KITTITAS COUNTY DEPARTMENT OF PUBLIC WORKS

MEMORANDUM

TO: All Staff
FROM: Public Works Plan Review Team
DATE: May 31, 2024
SUBJECT: BL-24-00008 Palmer

RECORD OF SURVEY

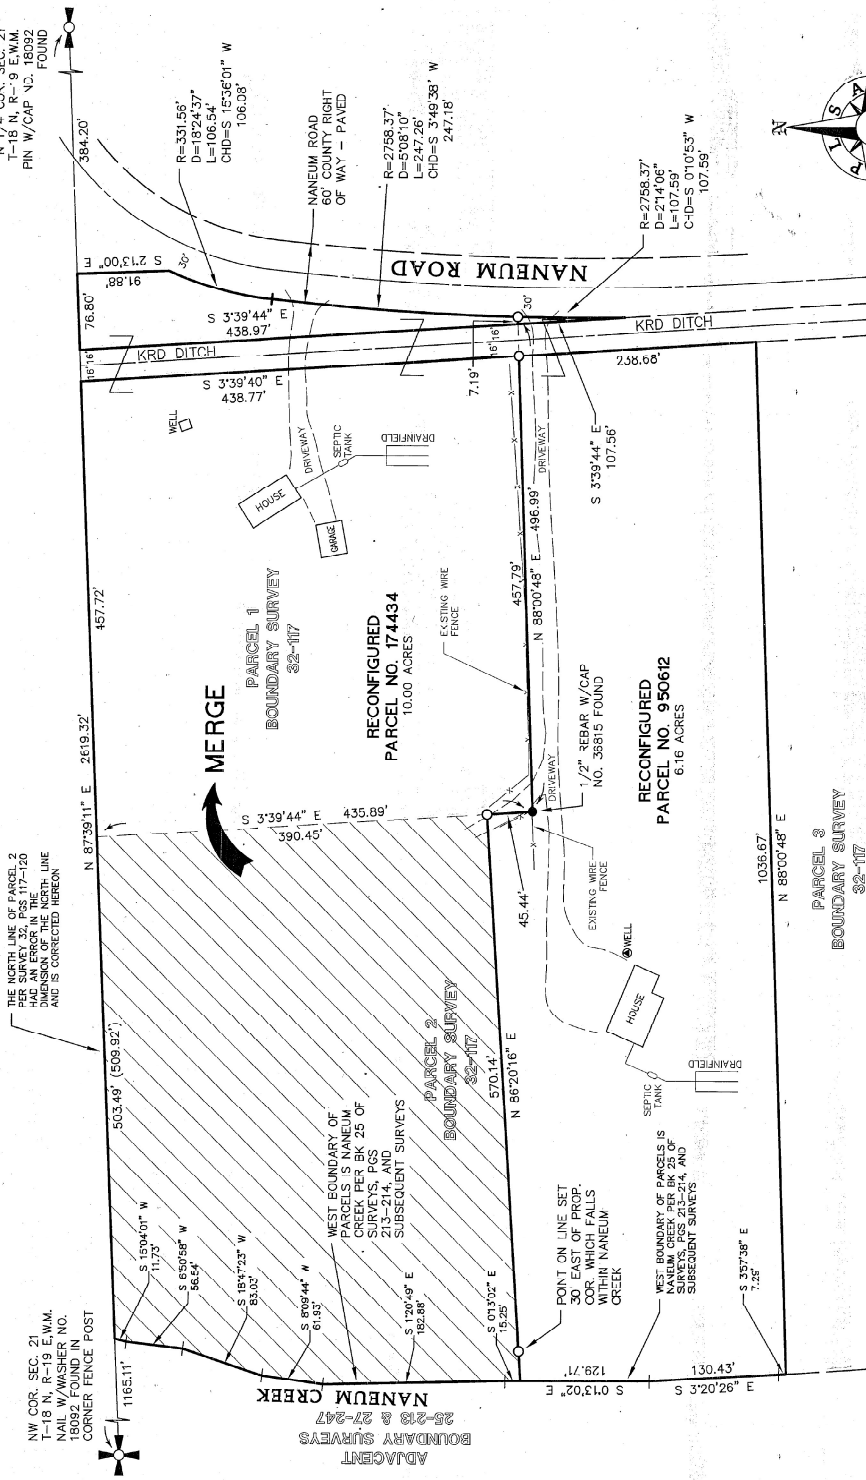
| SURVEY | <p>As the application deos not contain a survey map, comments are reserved until final. (JT)</p> <p>UPDATE 07/23/2024</p> <ol style="list-style-type: none">1. Include a title at the top of the page including "Record of Survey, Pt of NW1/4 of NE1/4 T18N., R19E., W.M., Kittitas County, Washington"2. Label full right of way width, ownership and surfacing for Naneum Rd. (EX: Naneum Rd. 60' County R/W – Paved)3. Show the 3 dimensions of the little sliver of land for that portion of Parcel 950612 lying East of Naneum Road.4. Include a "purpose of survey statement" similar to the following: The purpose of this survey is to identify the parcels and satisfy the conditions of |

| | <p>approval for a boundary line adjustment submitted to Kittitas County under application No. BL-24-00008.</p> <p>5. Please identify the West line of the survey as “West Boundary of Naneum Crk.” (per Sur:25-213, and subsequent surveys)</p> <p>6. The title report provided in the application does not match the area surveyed. A correct title report will need to be provided prior to final approval.</p> <p>OF NOTE (Changes not required)</p> <p>1. A lot closure report was not provided, nor were lot closures reviewed. Given the simple nature of this BLA, closures are not required.</p> <p>2. The North line of the transfer parcel does not match Survey: 32-117. While Survey 32-117 appears to be incorrect, the distance discrepancy could be noted, depending upon the surveyors interpretation of WAC:332-130-050(1)(f).</p> <p>3. Due to wrong title report being submitted, existing legal descriptions have not been compared to title documents. (JT)</p> <p>UPDATE 09/18/2024</p> <p>All prior comments have been addressed on the newest submittal.</p> |
